City of Albuquerque

RE: DRAINAGE PLAN FOR PRESBYTERIAN WAREHOUSE ADDITION
(J-14/D68A) ENGINEER'S STAMP DATED FEBRUARY 17, 1992

Based on the information provided on your submittal of February 18, 1992, the following concerns must be addressed prior to final approval:

GRADING AND DRAINAGE PLAN

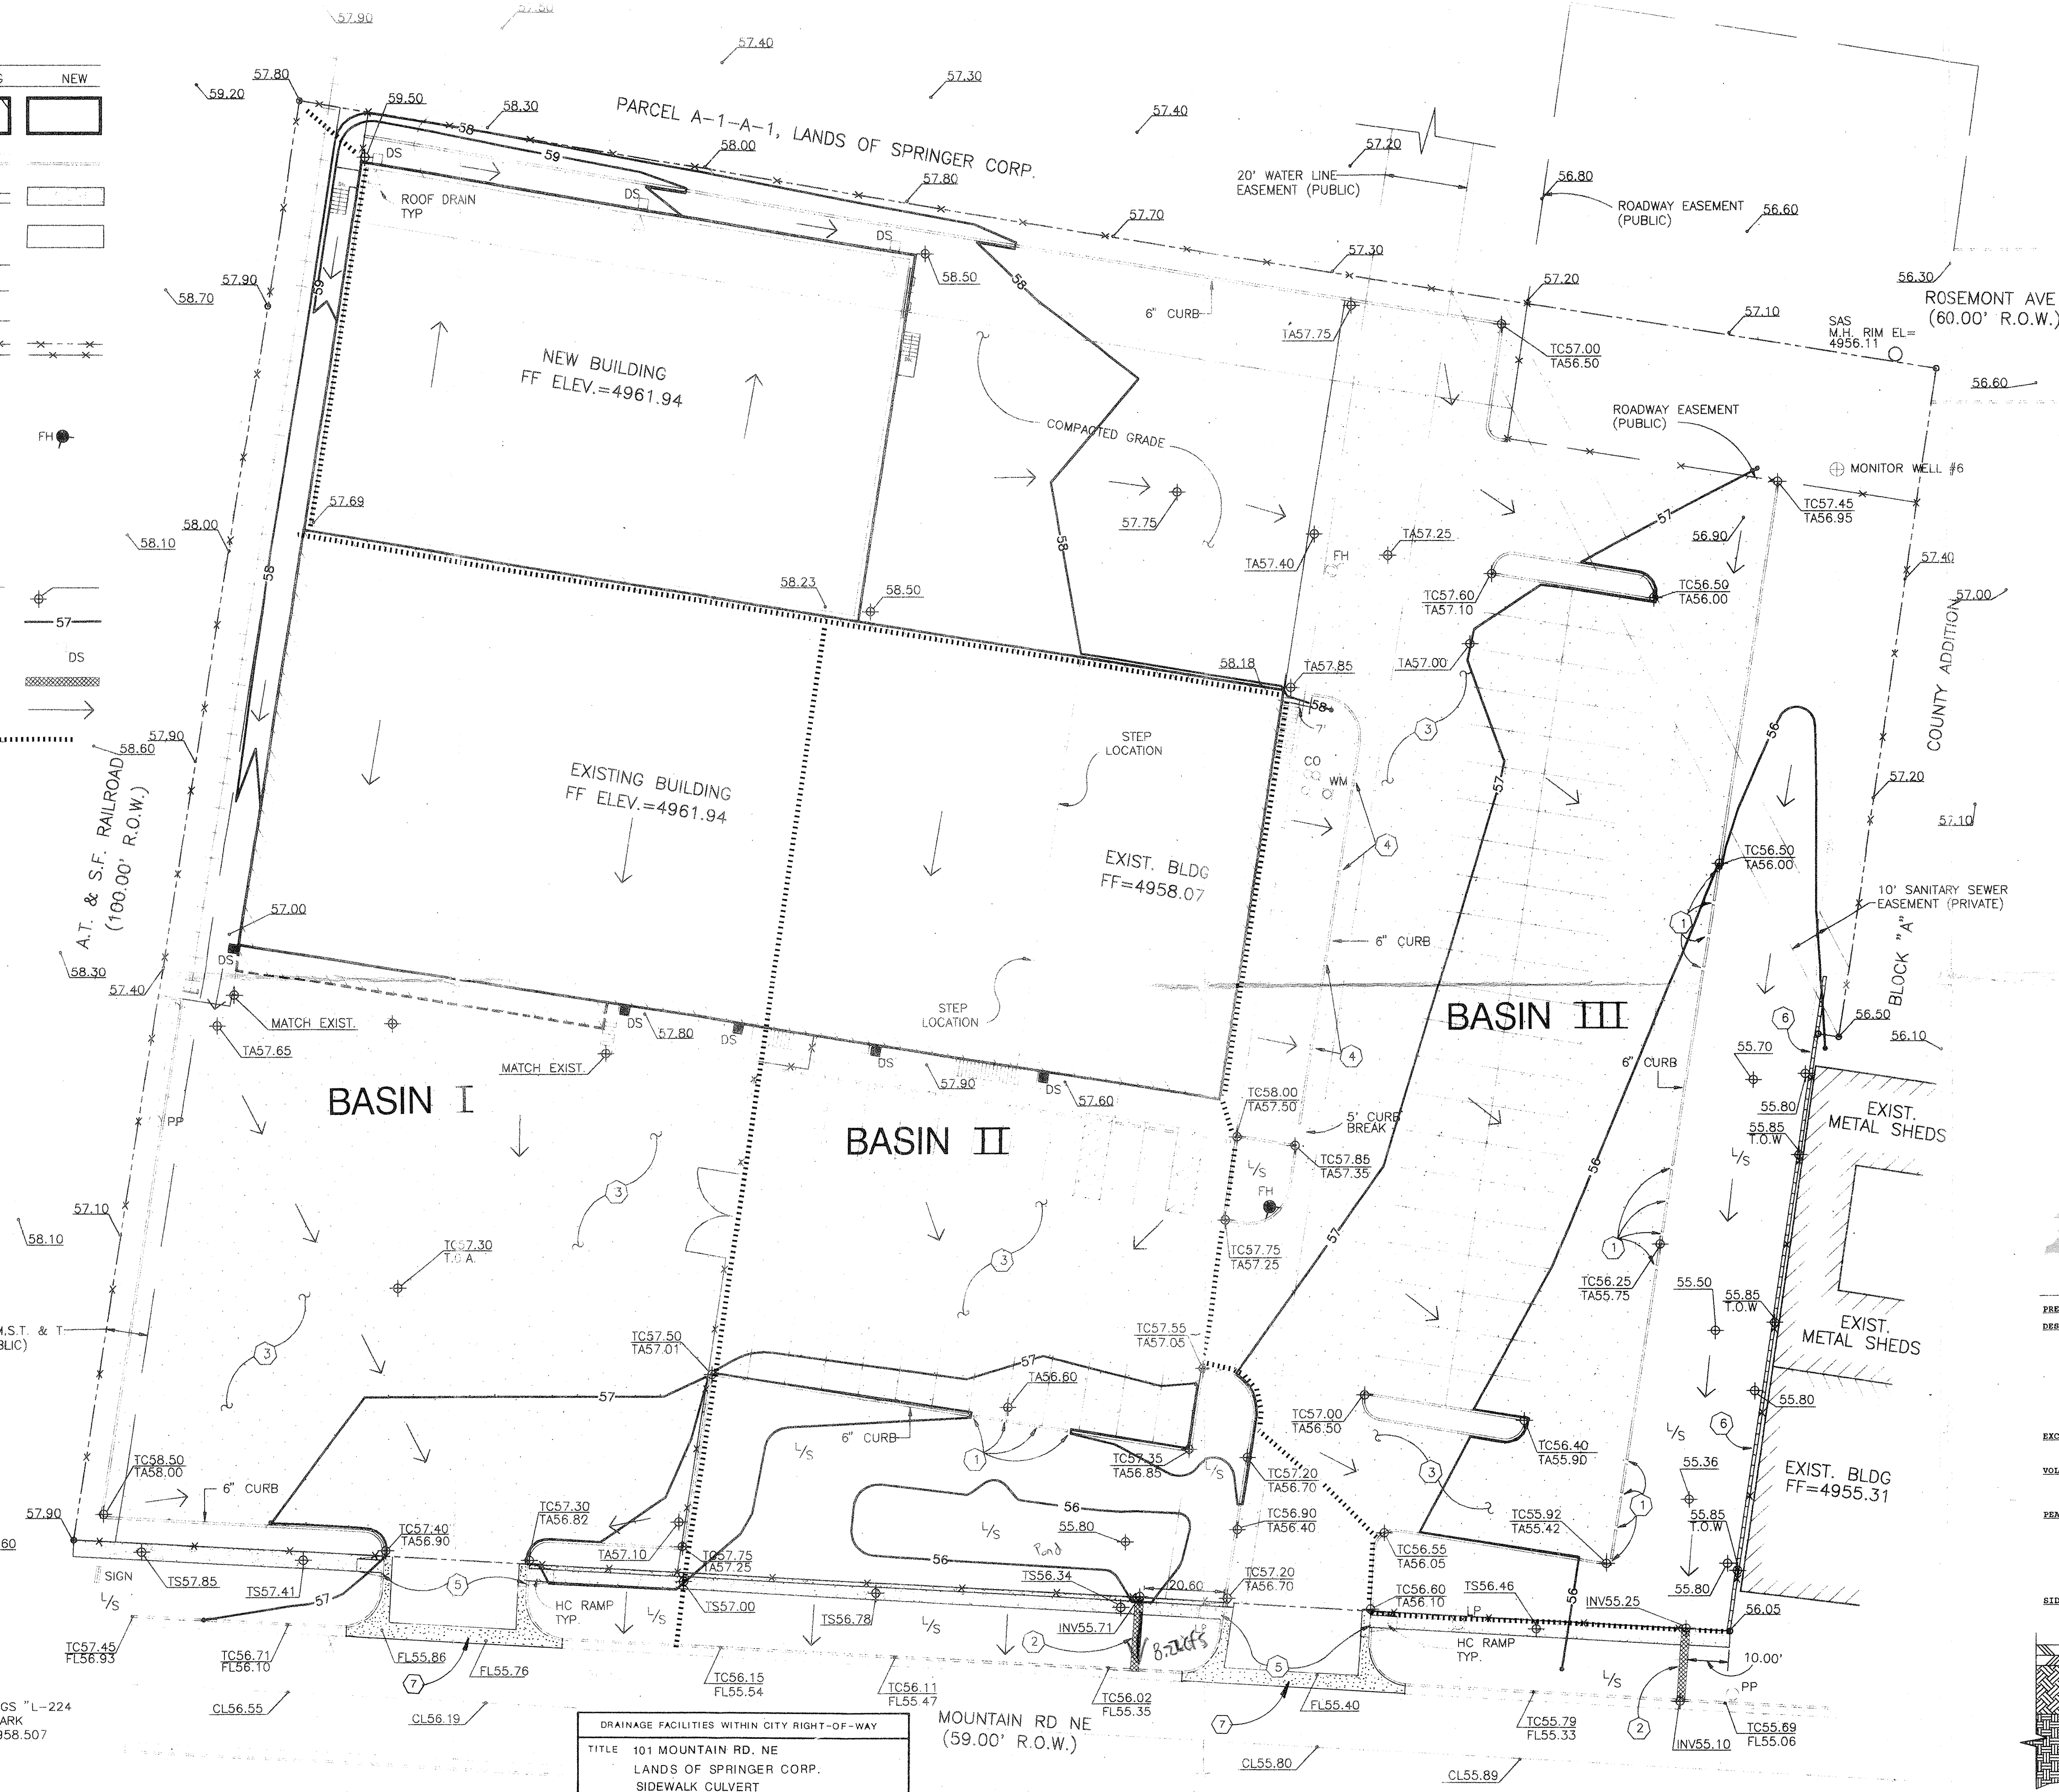
- ✓ 1. Identify what basins are going to each proposed sidewalk culvert and also provide the hydraulics for the culverts.
- ✓ 2. Sign-off block for the S.O. #19 format along with the six notes within the plan drawing.
- ✓ 3. Sidewalk culvert specs do not allow you to sawcut the face of the curb, you must remove the complete stone. Please remove that note from the plan drawing about the sawcut.
- ✓ 4. Two (2) copies of blueprints are required with your resubmittal.
5. Evaluation of your determination for free discharge onto Mountain Road.
INLET IN BROADWAY?
